## **WESTMEAD CATHOLIC COMMUNITY EDUCATION CAMPUS (SSD 10383) RESPONSE TO ADDITIONAL INFORMATION AND DESIGN AMENDMENTS**

This letter has been prepared by Ethos Urban on behalf of the Catholic Education Diocese of Parramatta (CEDP) to respond to the Department's Request for Information (RFI) dated 19 May 2021, including detailed comments and questions set out in subsequent correspondence dated 3 June 2021 and 4 June 2021, relating to traffic and transport and open space, respectively.

SITE PLAN
sheet

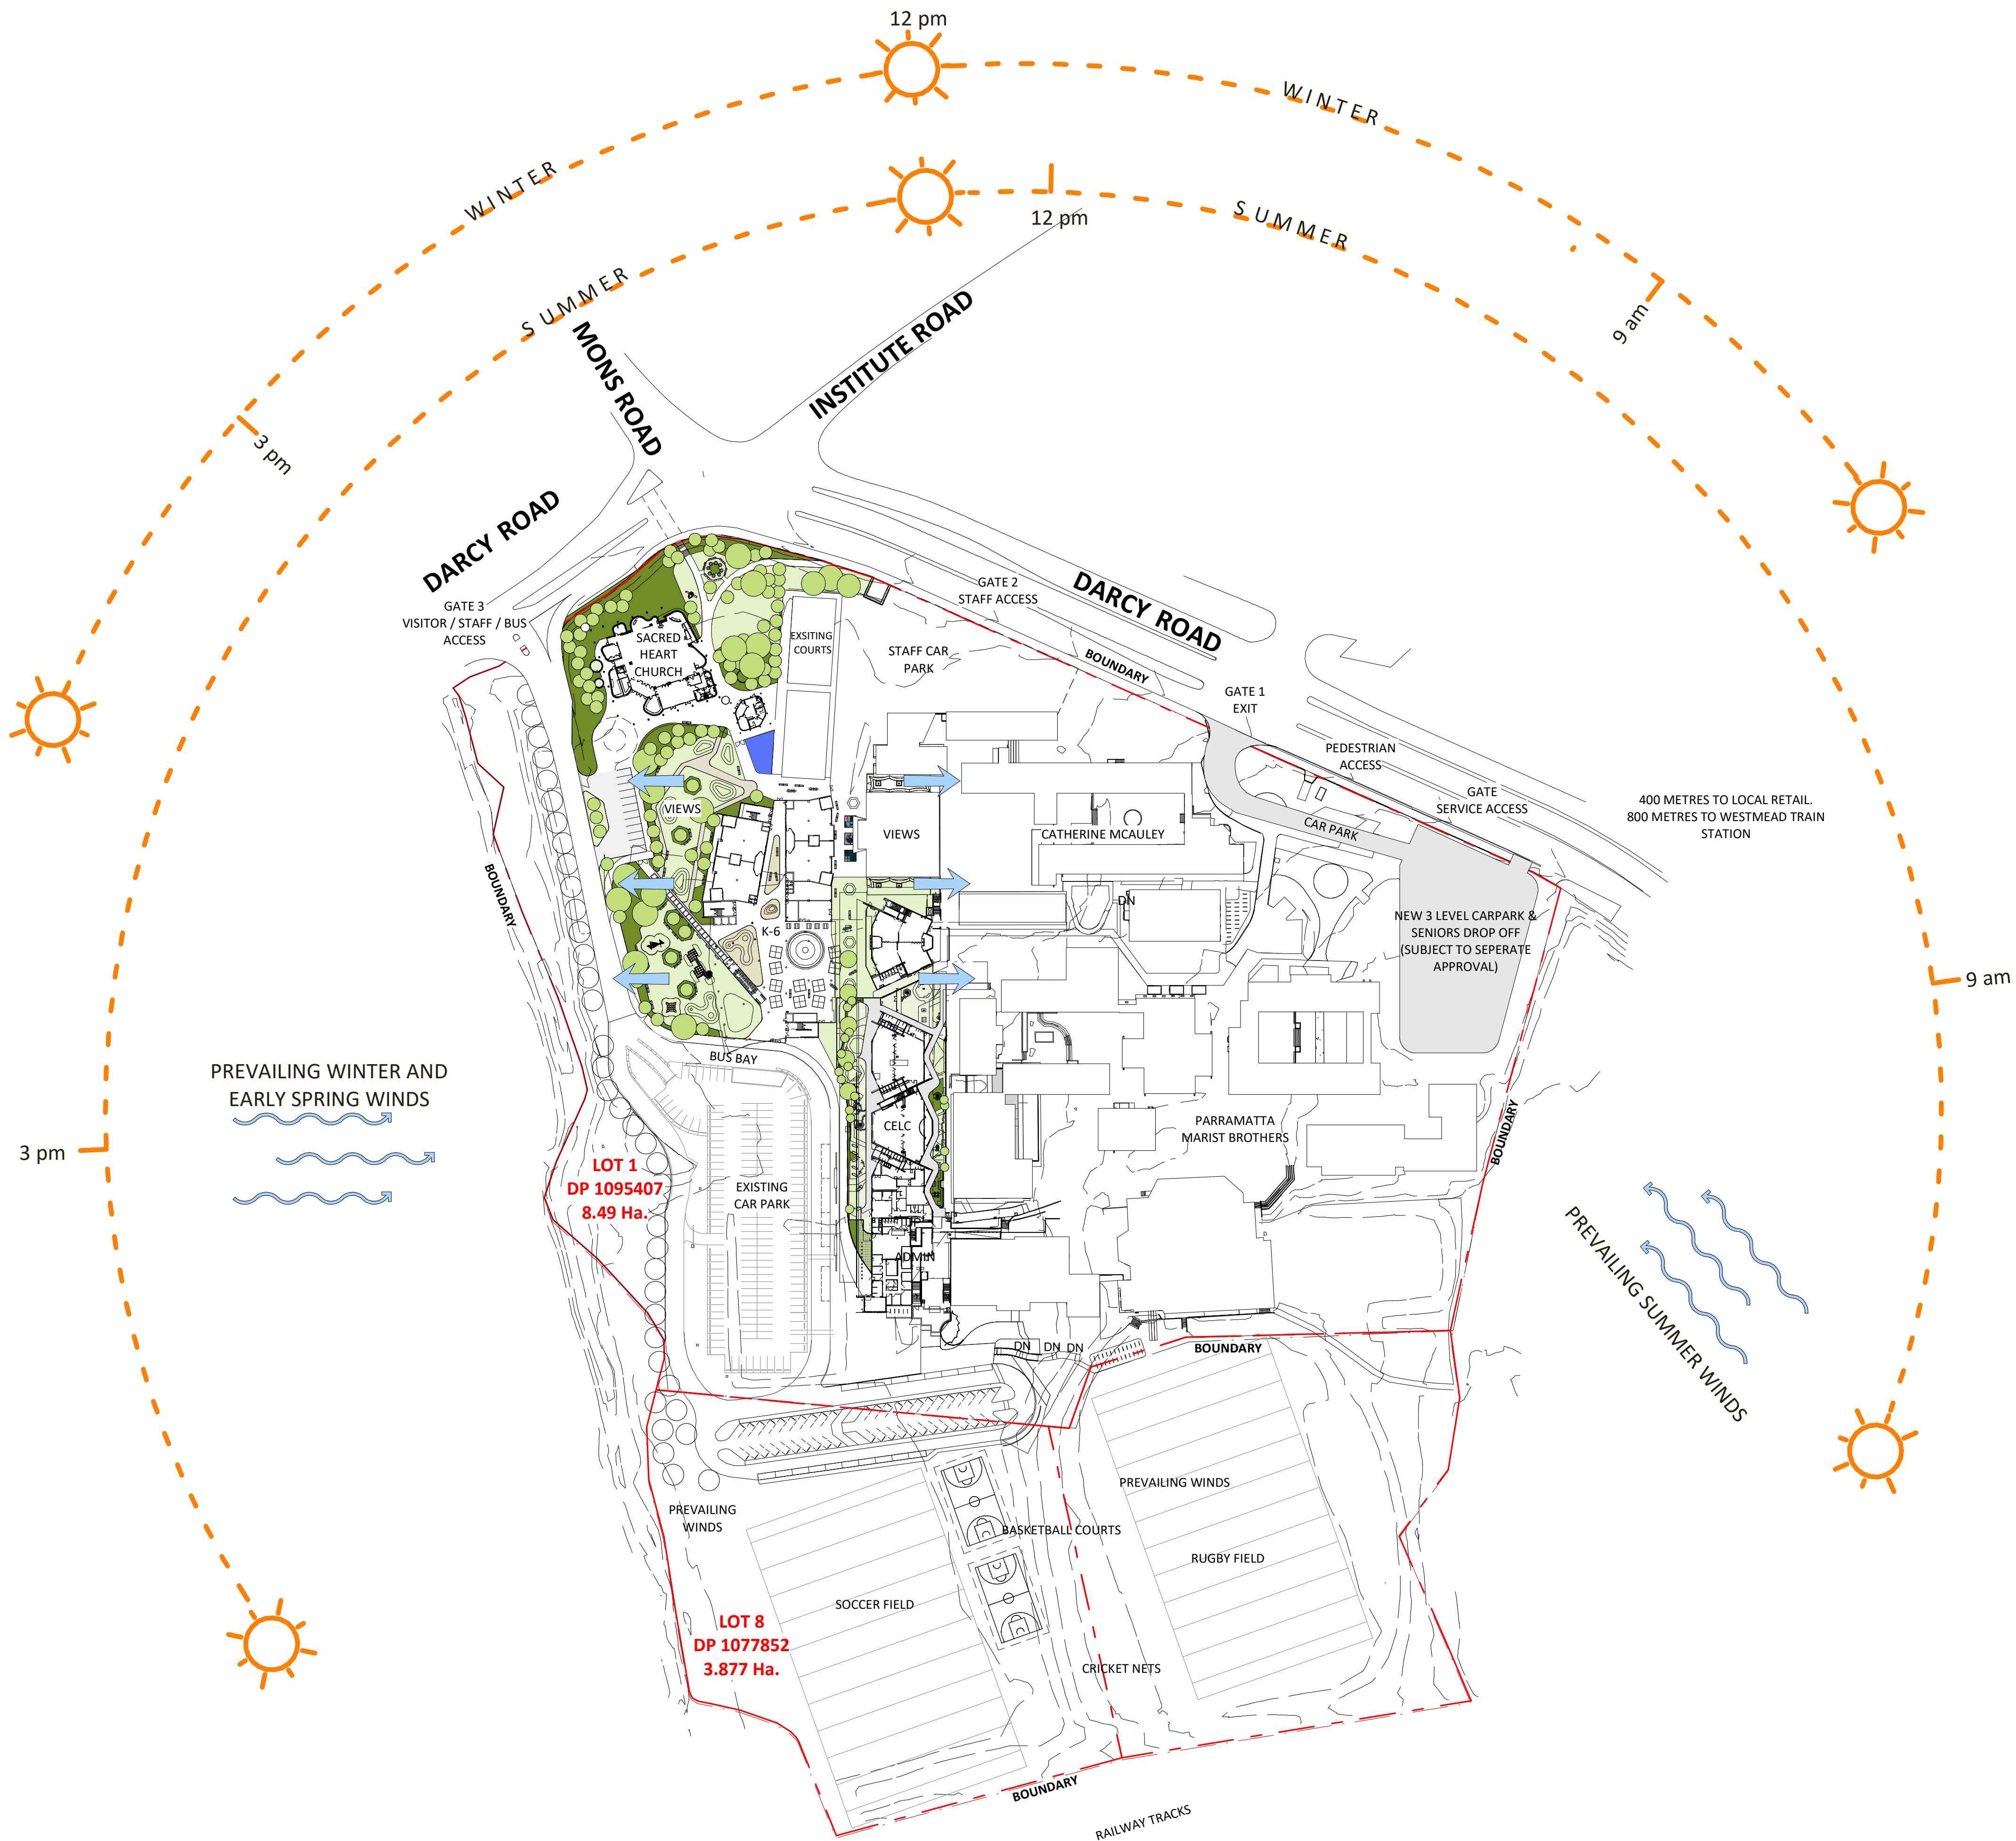
To facilitate the amendments to the Darcy Road – Mother Teresa intersection, the Parish Church needs to be repositioned. The original and proposed location of the Parish Church is shown at **Figure 4**. The Parish Church is proposed to be moved slightly to the east (by up to 8m) and will be rotated slightly clockwise (by 16 degrees). The Cross structure is also proposed to be relocated to align with the reorientated Church.

As noted above, there are no changes proposed to the number of car or bicycle parking spaces. However, several minor design changes have been made to accommodate the relocation of the Church, to respond to the recommendations of the RSA and due to ongoing design development. The changes are shown in **Figure 5** and comprise:

- Reconfiguration of the Parish car park to improve access and safety, with passengers now having direct access to the pedestrian footpath;
- Reconfiguration of the bicycle parking area to the west of the sports courts to include the spaces that used to be located to the north of the primary school building; and
- Introduction of a trafficable porte-cochere for processional vehicles.
